A47 North Tuddenham to Easton

Scheme Number: TR010038

Volume 9 **9.27 Applicant's Responses to Deadline 6** **Comments**

January 2022

APPENDIX B. ALTERNATIVE OPTION DEPARTURES

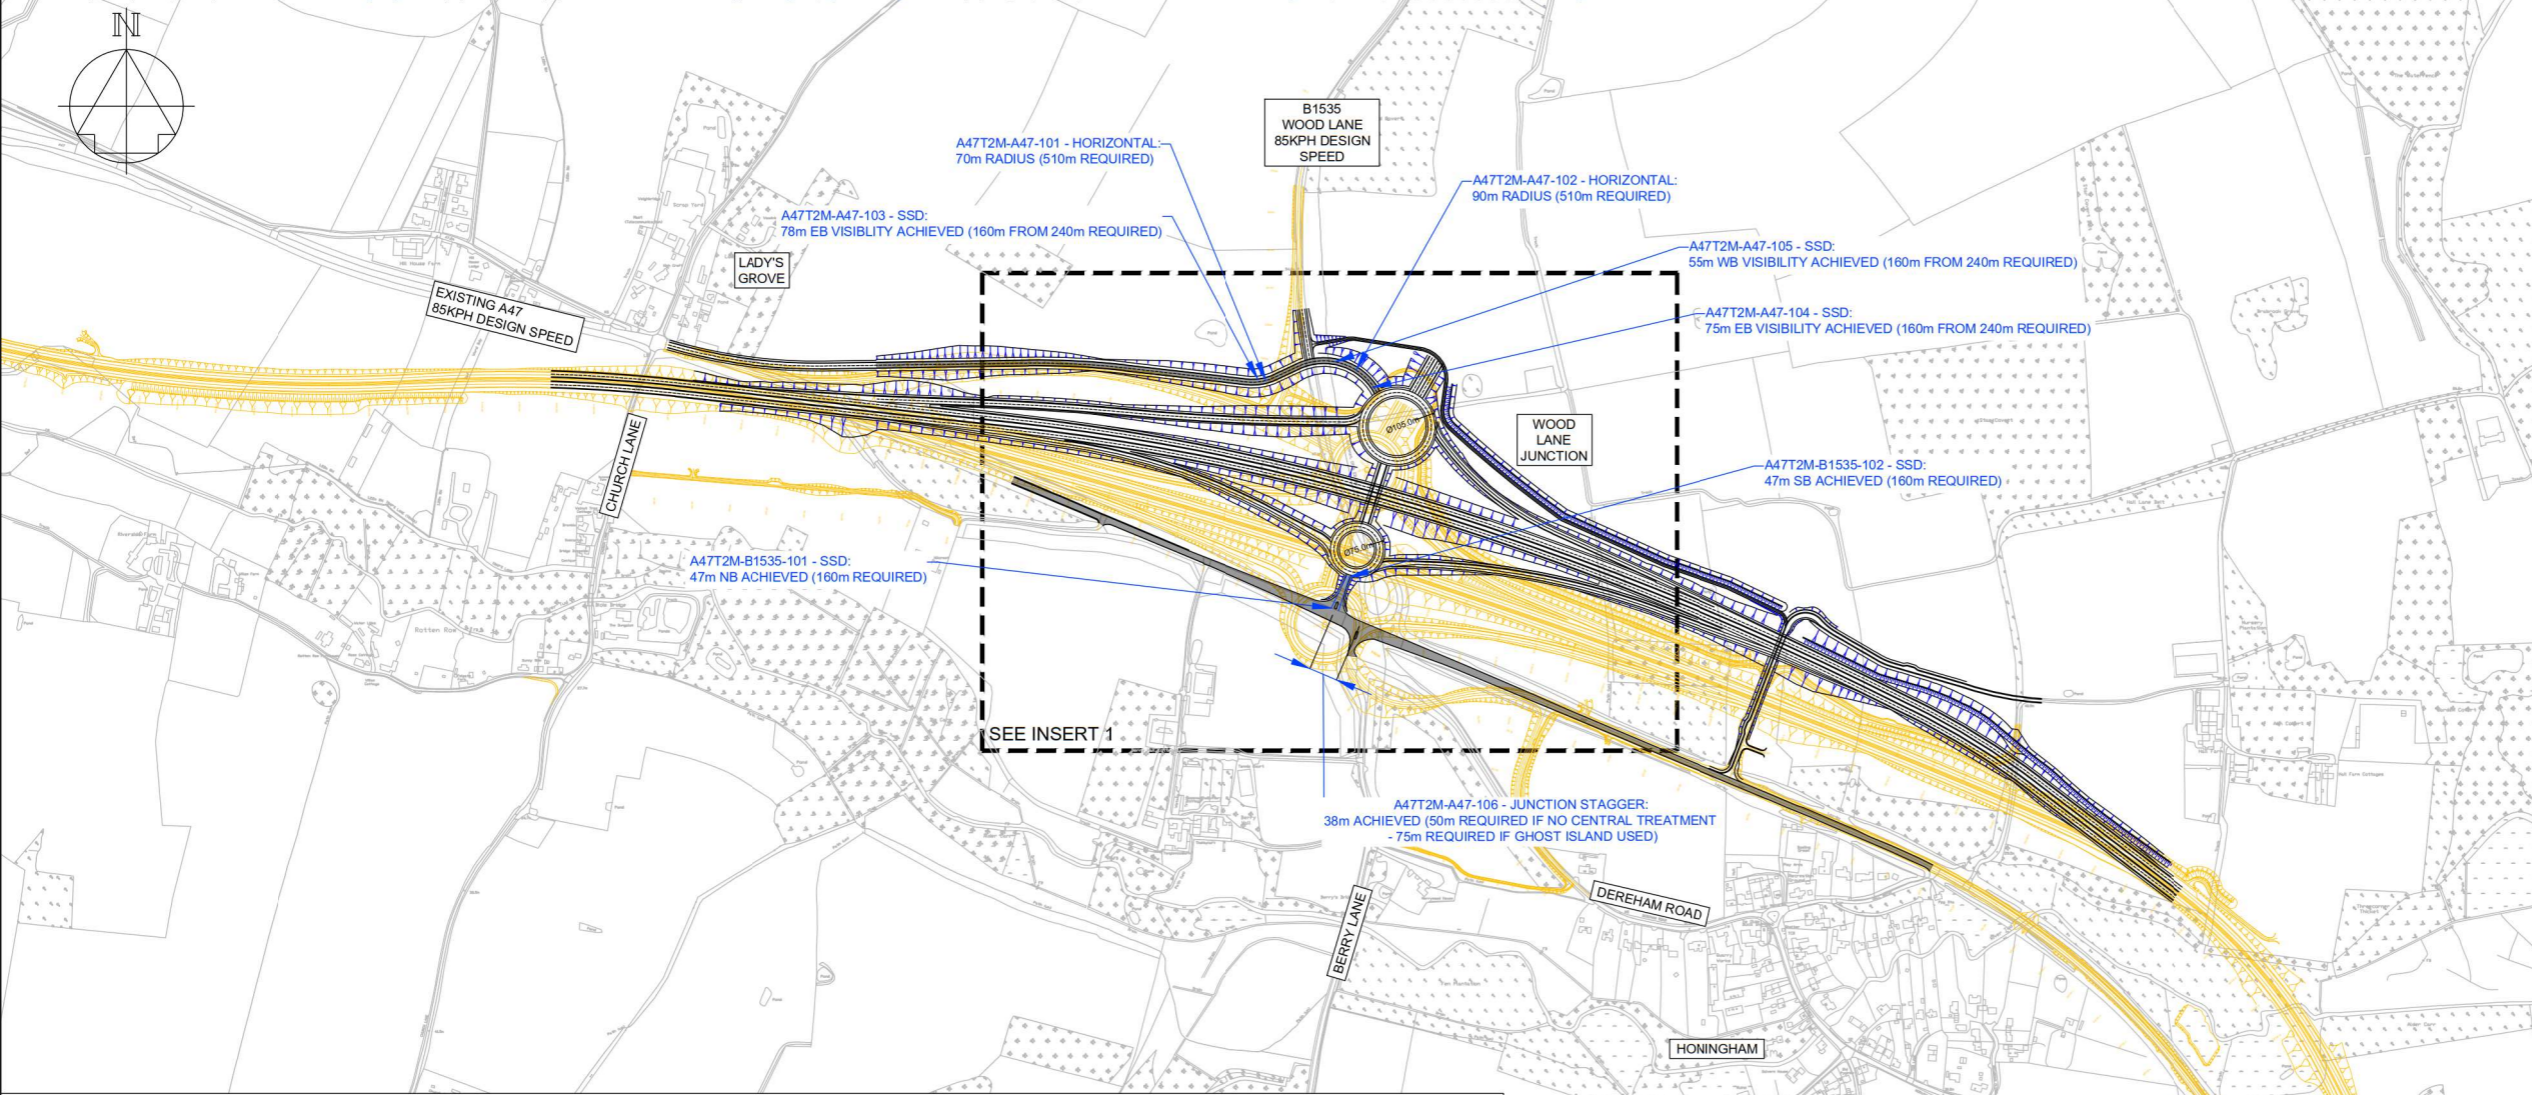
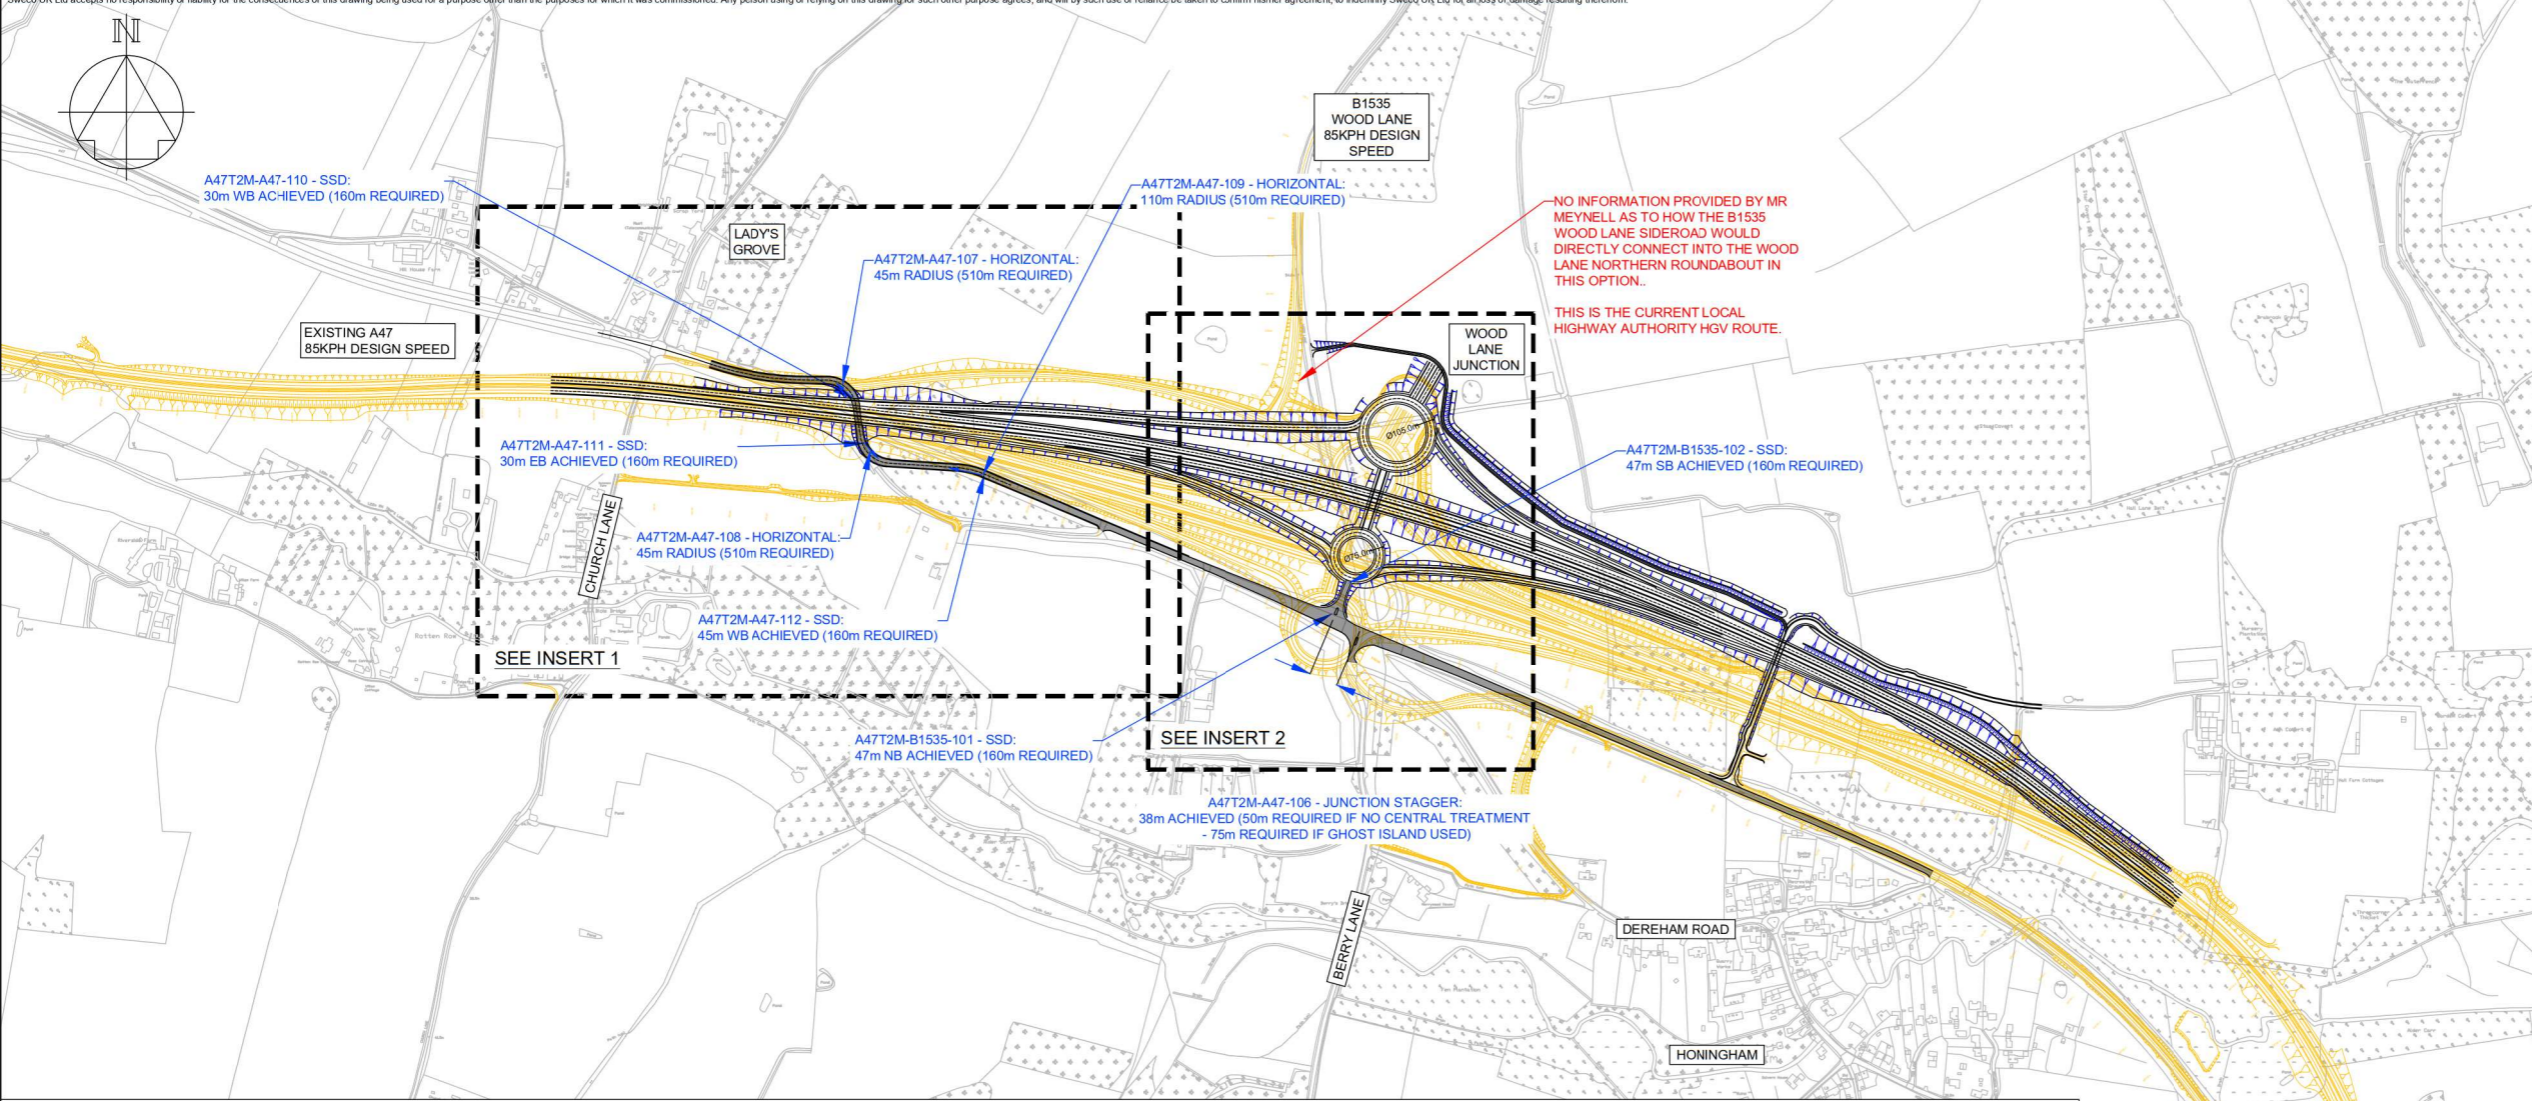
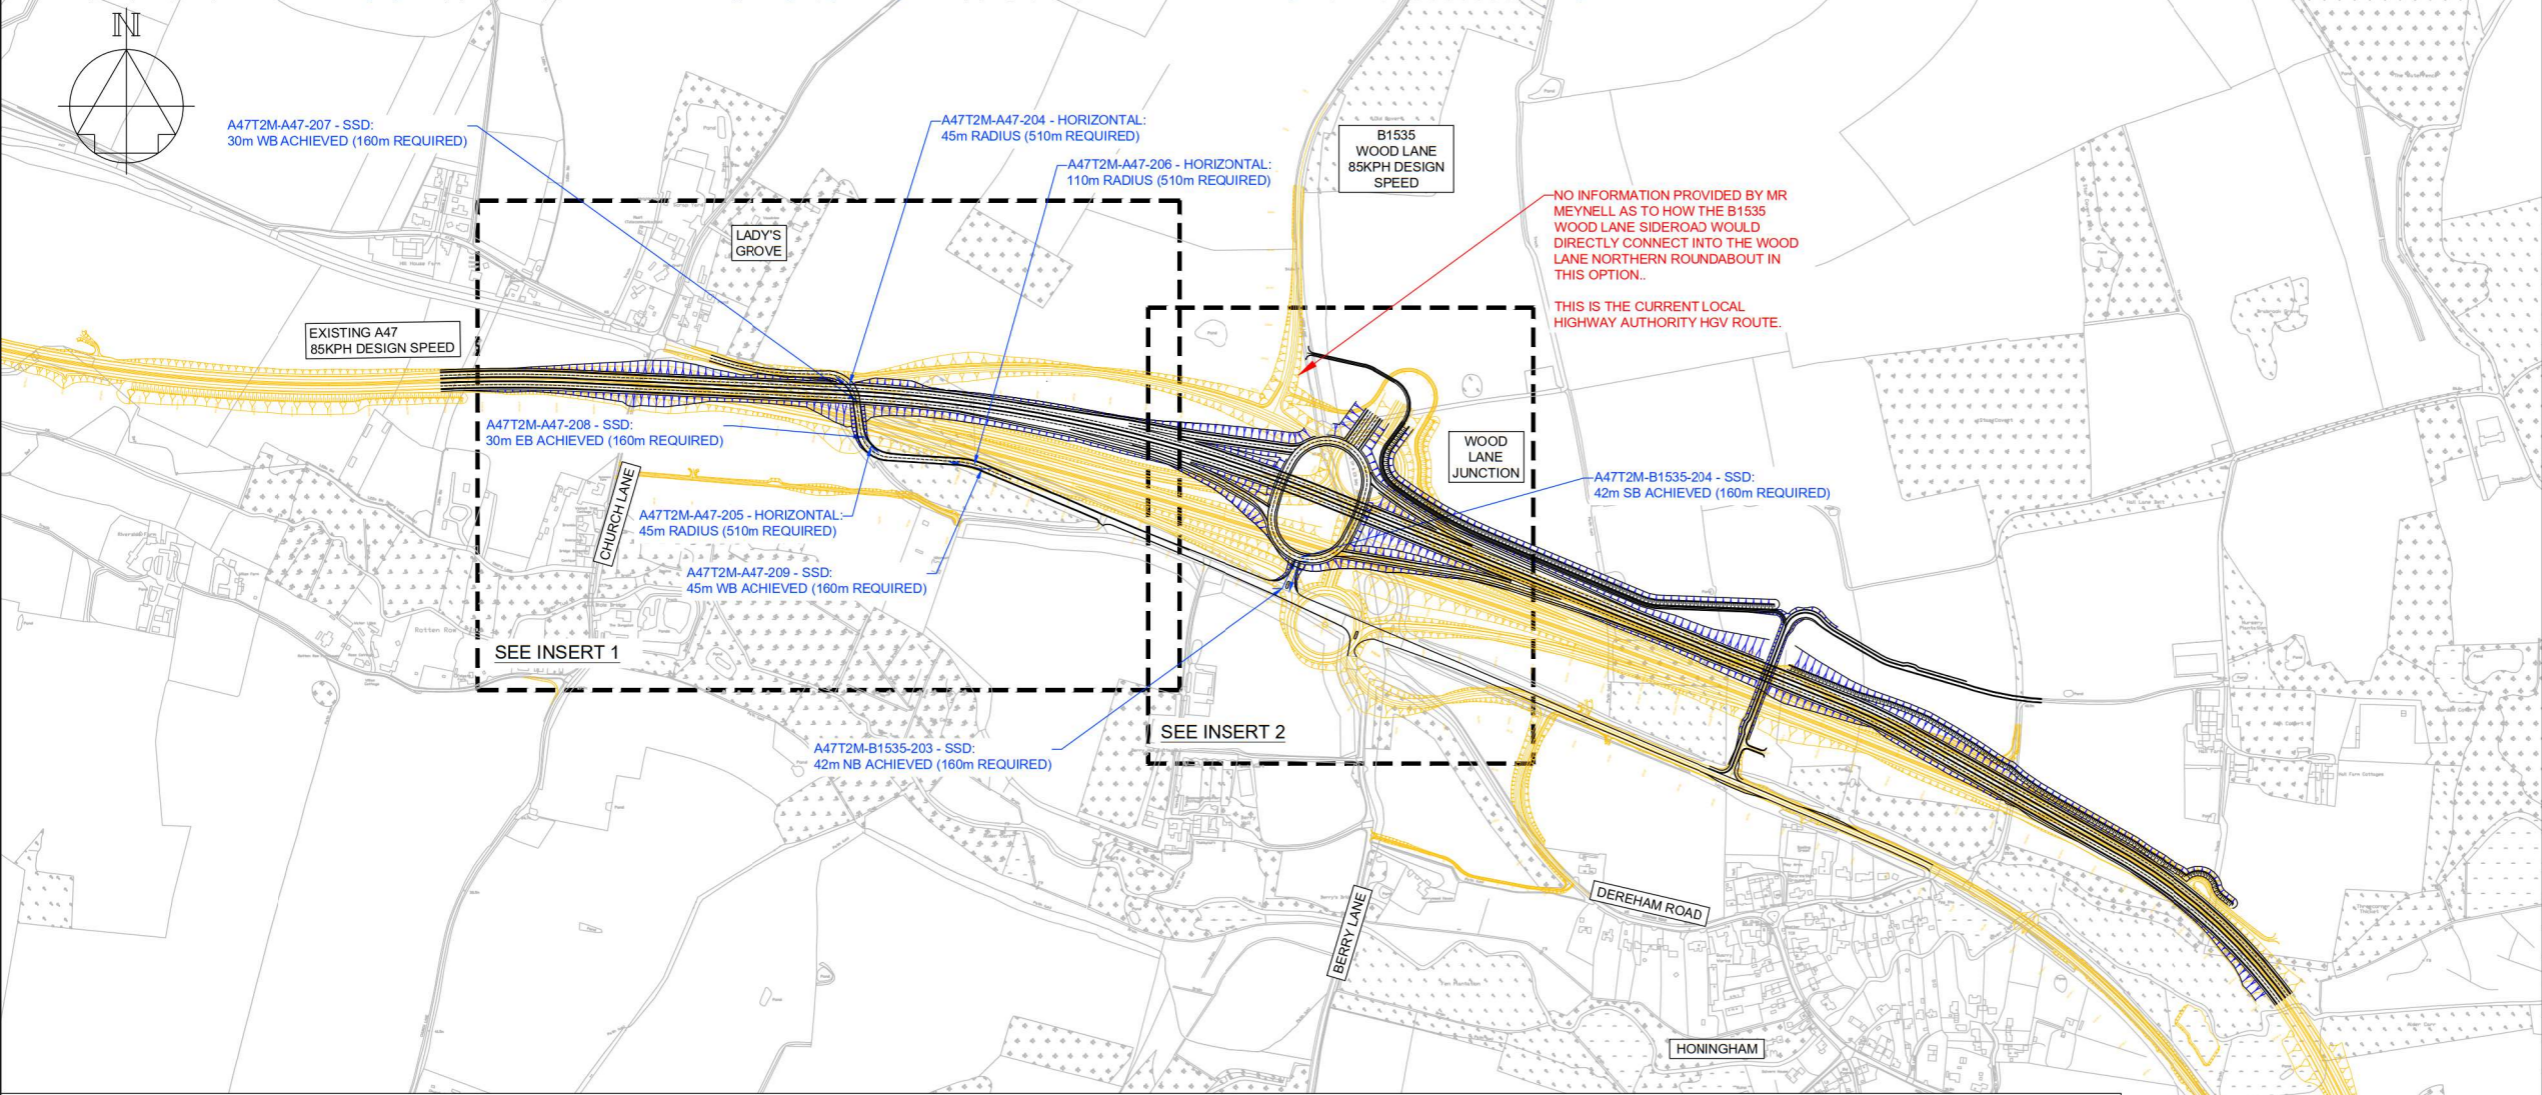
| Comment | Applicant Response |
|--|--|
| <p>ACM claims a reasonable alternative scheme design with a number of different options for it, remains fully capable of avoiding adverse impact on the cultural heritage interests and preserving the integrity of the [REDACTED] these or any other options to adjust the location of the junction and its associated roads and structures to reduce the effects on the Estate, have not so far been adopted.</p> | <p>The Applicant has undertaken an assessment of the alternative Wood Lane junction options, as reported in the updated '9.15 - Alternative Wood Lane Junction Options Appraisal' (REP6-015) issued at Deadline 6.</p> <p>The analysis demonstrates that each of the alternative options proposed has significant deficiencies across a range of key criteria where assessments were possible. It follows that the current Scheme design remains the preferred Wood Lane junction design option with regards location and layout to be taken forward as the most appropriate solution in the location.</p> <p>This conclusion is supported by Norfolk County Council in their Deadline 6 Submission 'Comments on any additional information/submissions received by D5' which also states "...the County Council can confirm that it supports the Applicant's proposal for this junction."</p> <p>The provision of Wood Lane junction has also been supported by the relevant district councils since statutory consultation, as reflected in the below Examination submissions at Deadline 4:</p> <ul style="list-style-type: none"> • Statement of Common Ground with Breckland Council (REP4-004) • Statement of Common Ground with Broadland District Council (REP4-005) • Statement of Common Ground with South Norfolk Council (REP4-006) |

| Comment | Applicant Response |
|---|--|
| <p><i>Regarding Applicant's Response at Deadline 5 - REP5-016, Applicant's Appraisal of Alternatives (AS-022) and REP4-016 size of Wood Lane junction.</i></p> <p>The original Appraisal was responded to on behalf of ACM at REP4-023 Appendix A (Technical Note by Mr Joe Ellis). The updated version of the Appraisal was not submitted by the Applicant at Deadline 5 and will be responded to by ACM when received.</p> <p>REP4-016 did not provide evidence, only an unsupported statement.</p> <p>ACM has asked the Applicant to provide cross sections of the Wood Lane junction in order to be able to understand more clearly the effect its south side as proposed on the BHE and Honingham village and these should be provided also to Honingham PC.</p> | <p>The Applicant has undertaken an assessment of the alternative Wood Lane junction options, as reported in the updated '9.15 - Alternative Wood Lane Junction Options Appraisal' (REP6-015) issued at Deadline 6.</p> <p>The Wood Lane junction long sections, showing how the Scheme landscaping will screen the [REDACTED] are provided in Appendix A of the Applicant's Response to Examining Authority's Third Written Questions (REP6-018) issued at Deadline 6. These have also been issued directly to Mr Meynell. Updated cross sections have also been issued as Appendix A to the Applicant's Written Summary of Oral Submissions at ISH3 (TR010038/EXAM/9.29) submitted at Deadline 7.</p> |
